DEVIATION REQUEST AND DECISION FORM

Cul-de-sac Deviation Request

May 2022

Project Name : Forest Heights Estates

FOREST HEIGHTS CIRCLE  
GRADING & EROSION CONTROL PLAN  
EROSION CONTROL DETAILS

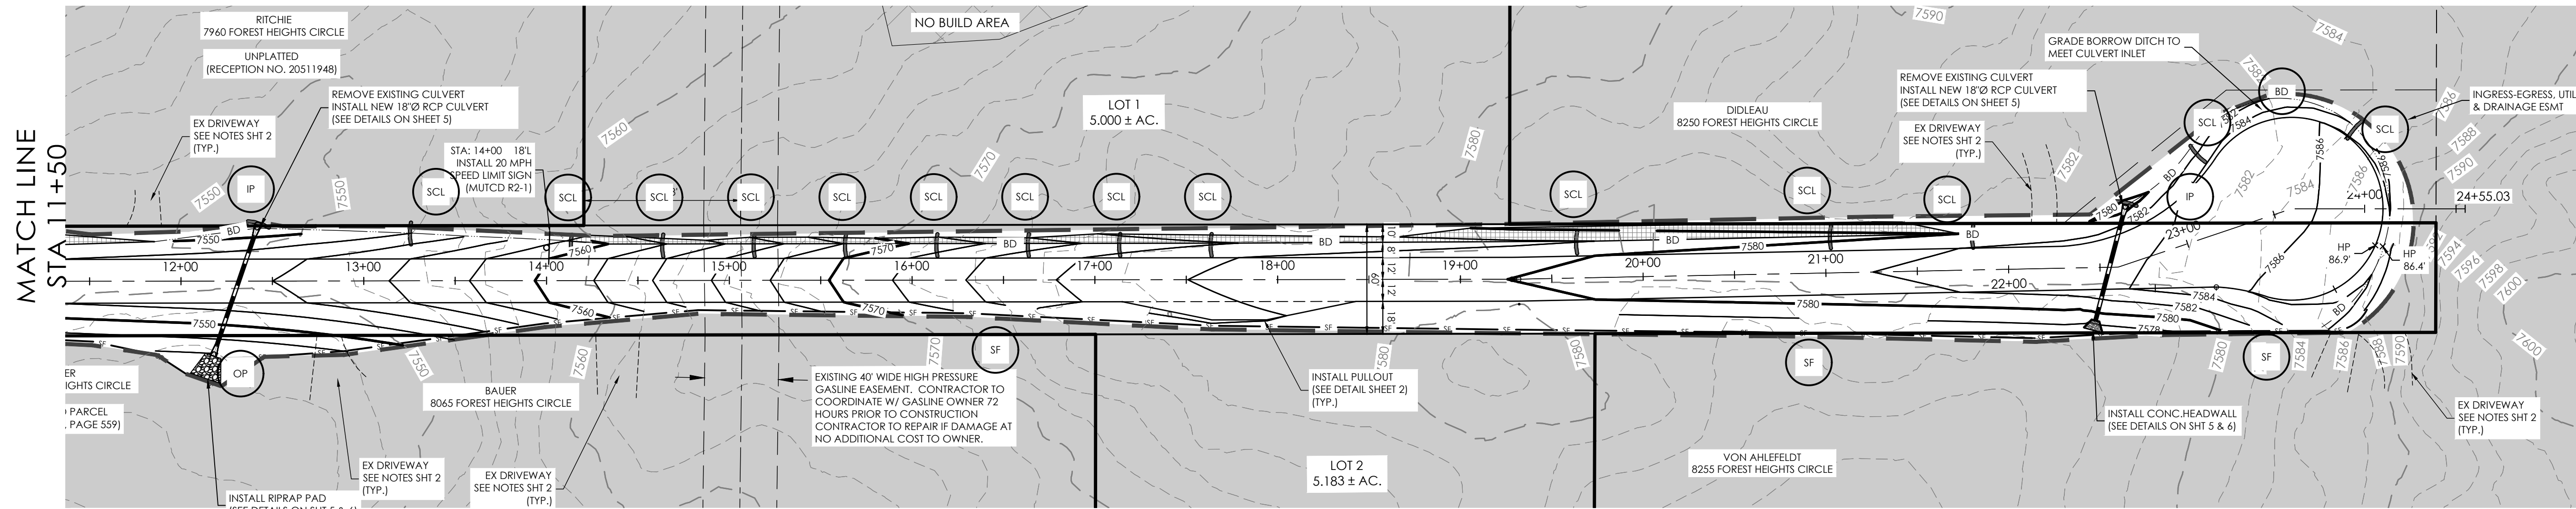
Please also state that the development meets the requirements of the County's MS4

FOREST HEIGHTS CIRCLE
CONSTRUCTION DRAWINGS
PLAN AND PROFILE
13+50 TO 23+75

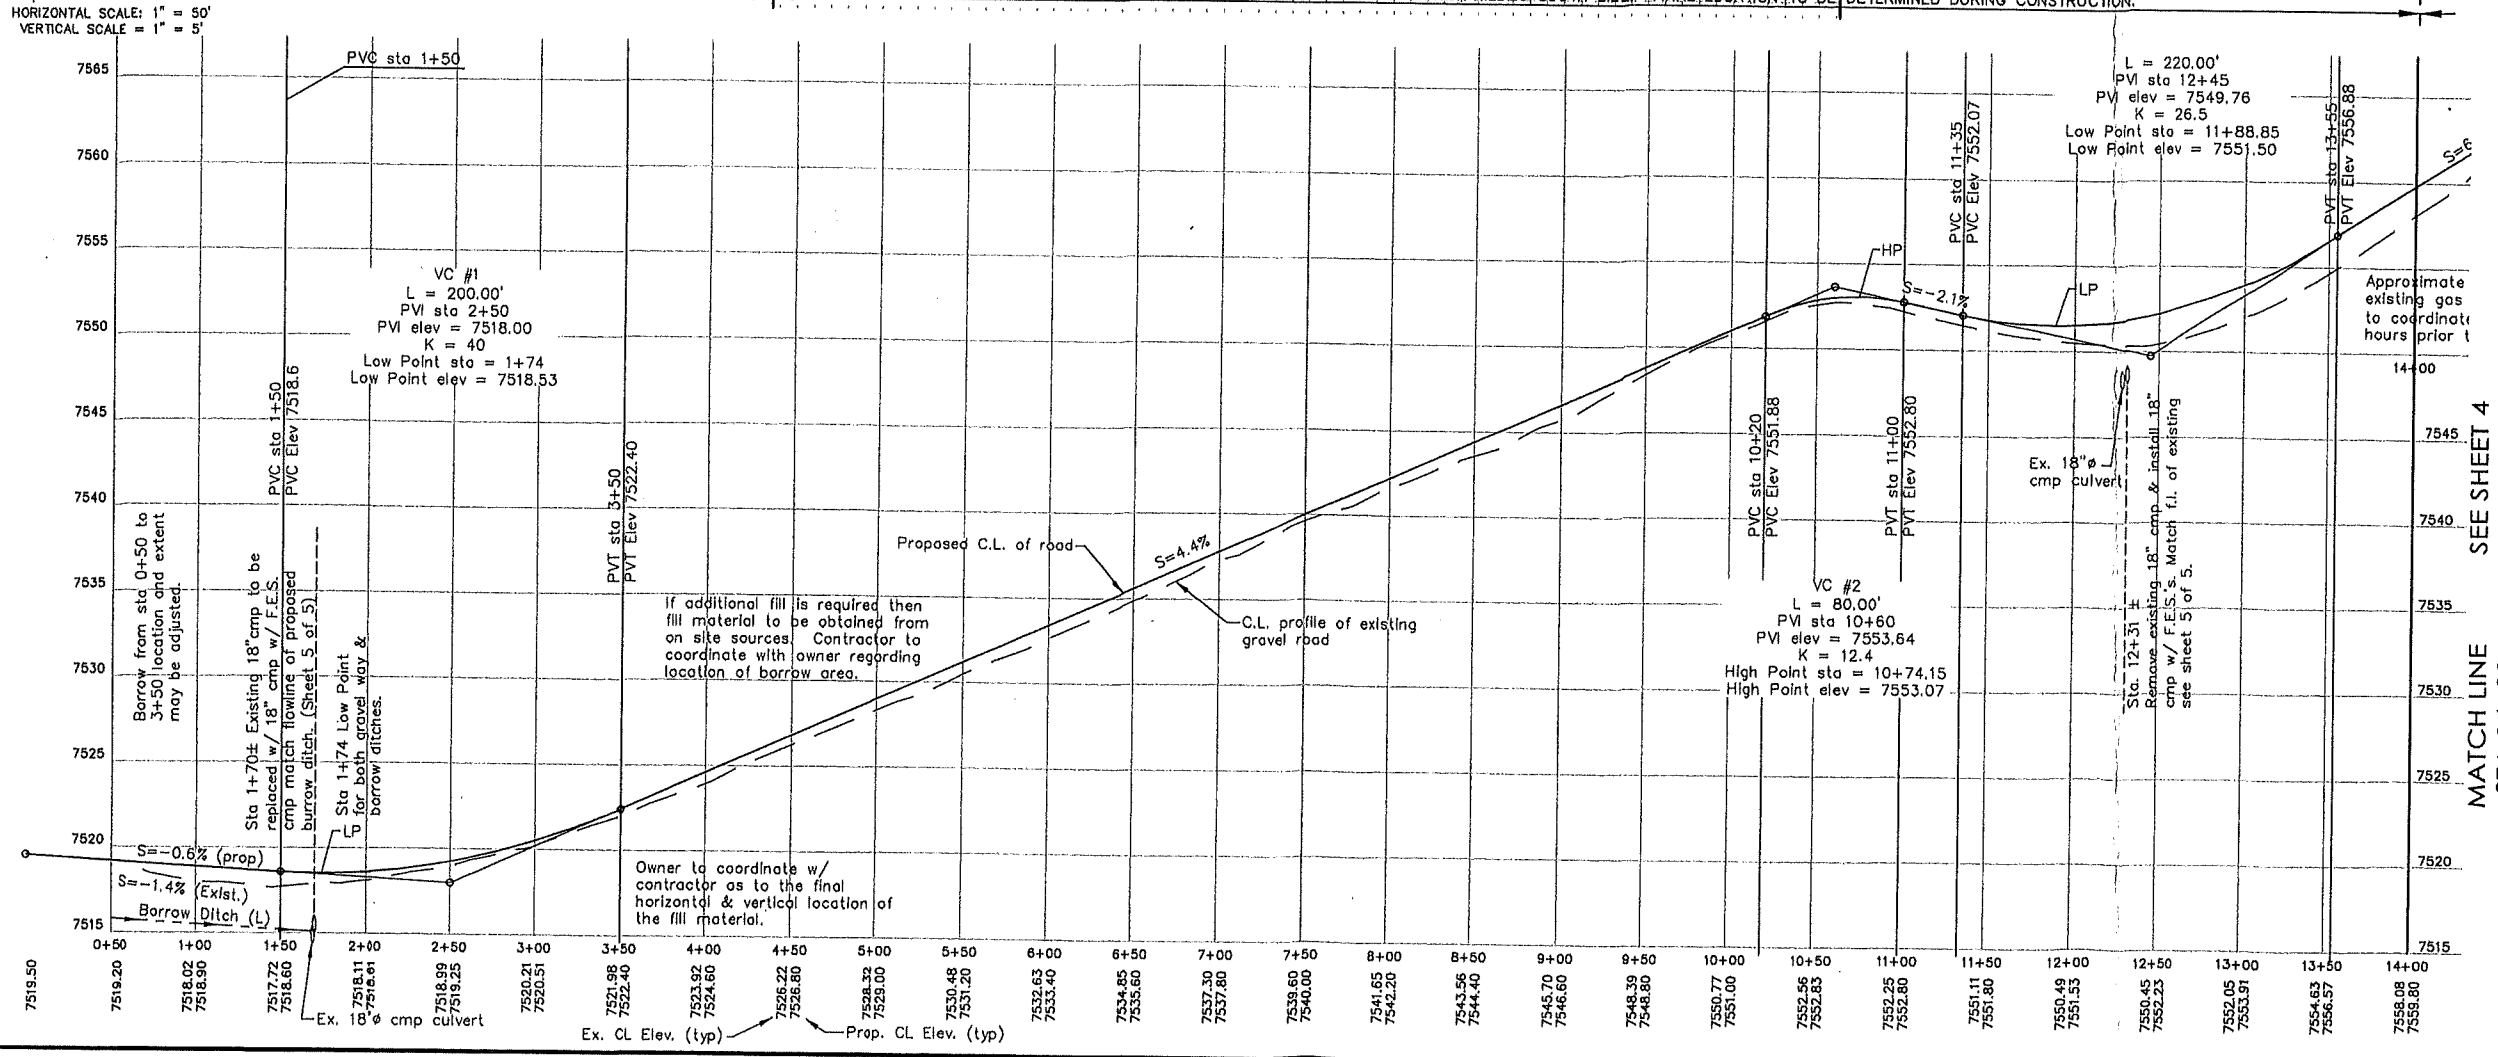
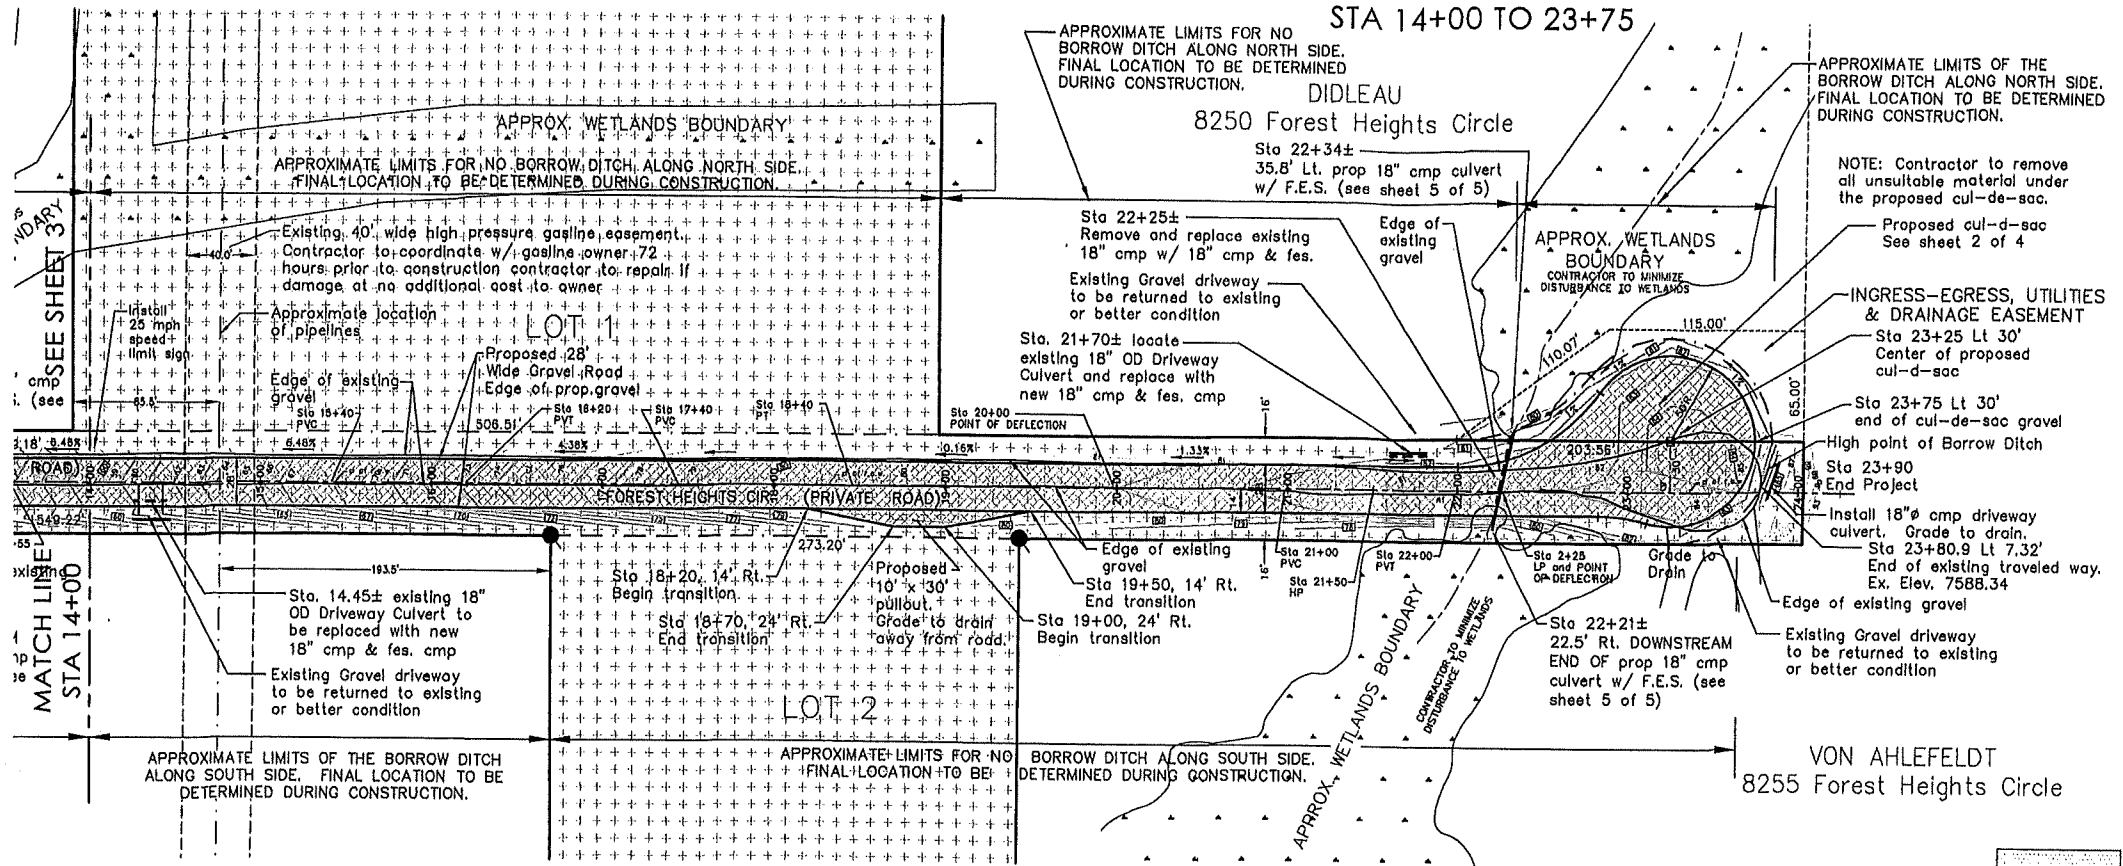
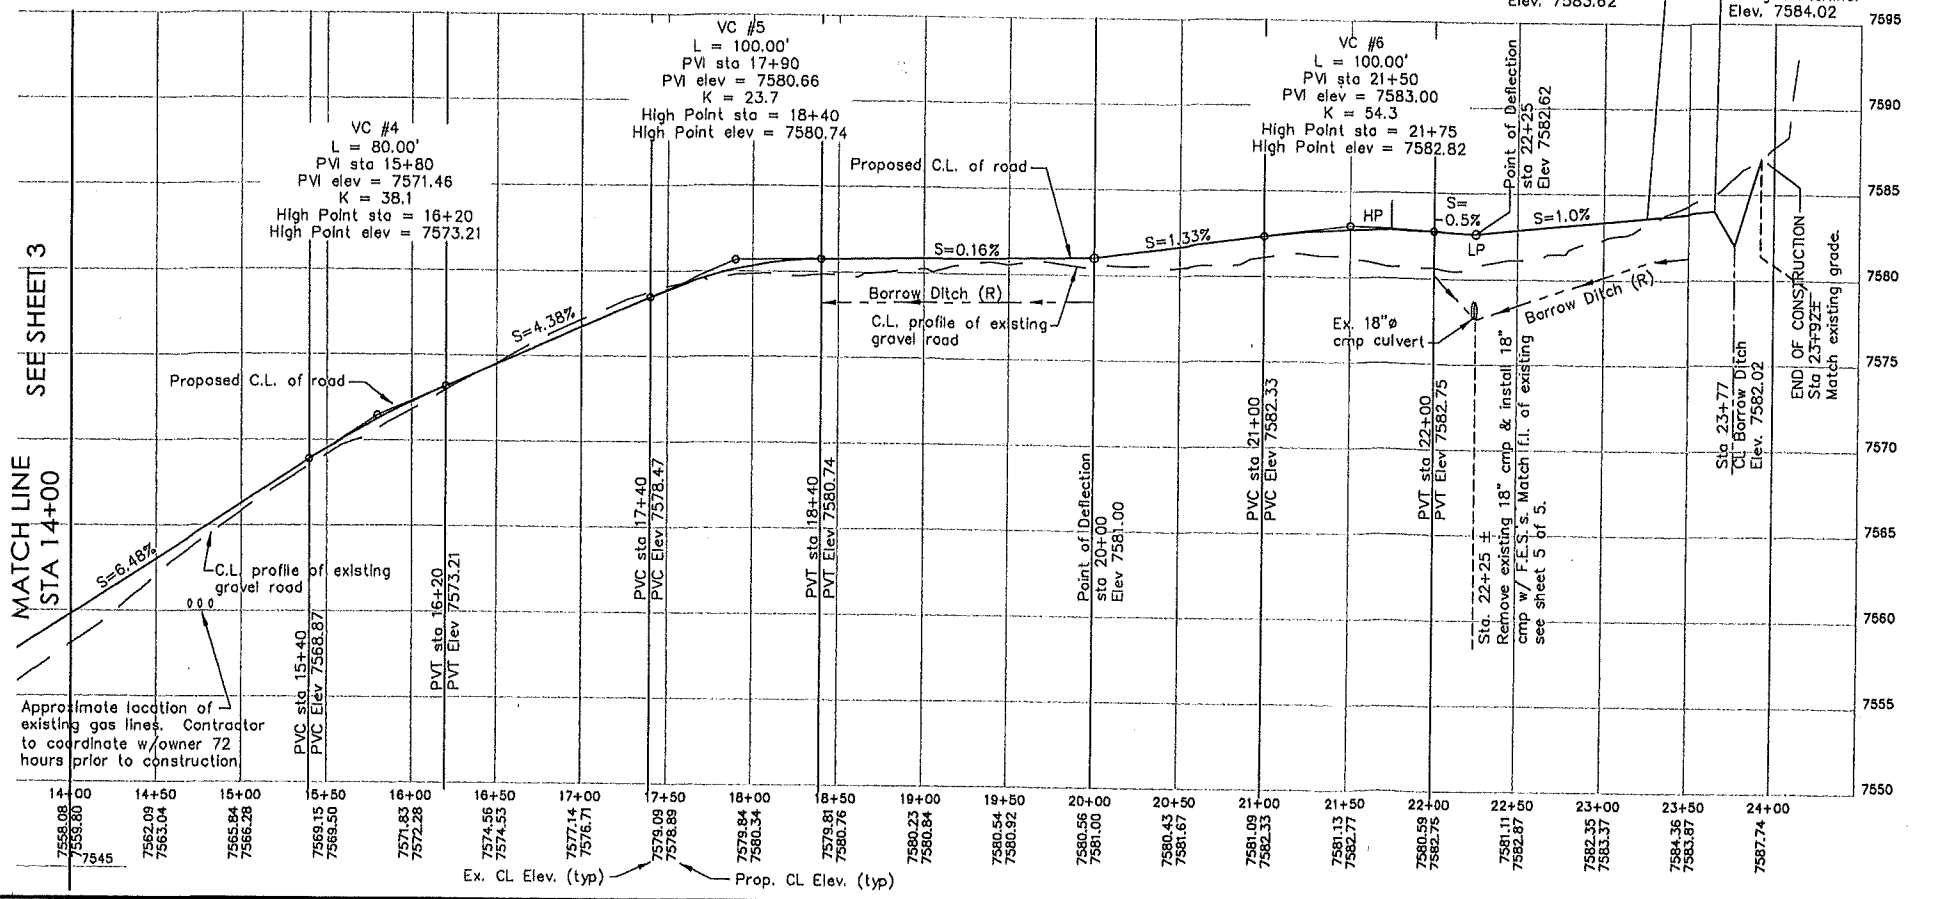
25 mph signs are indicated in the CD's
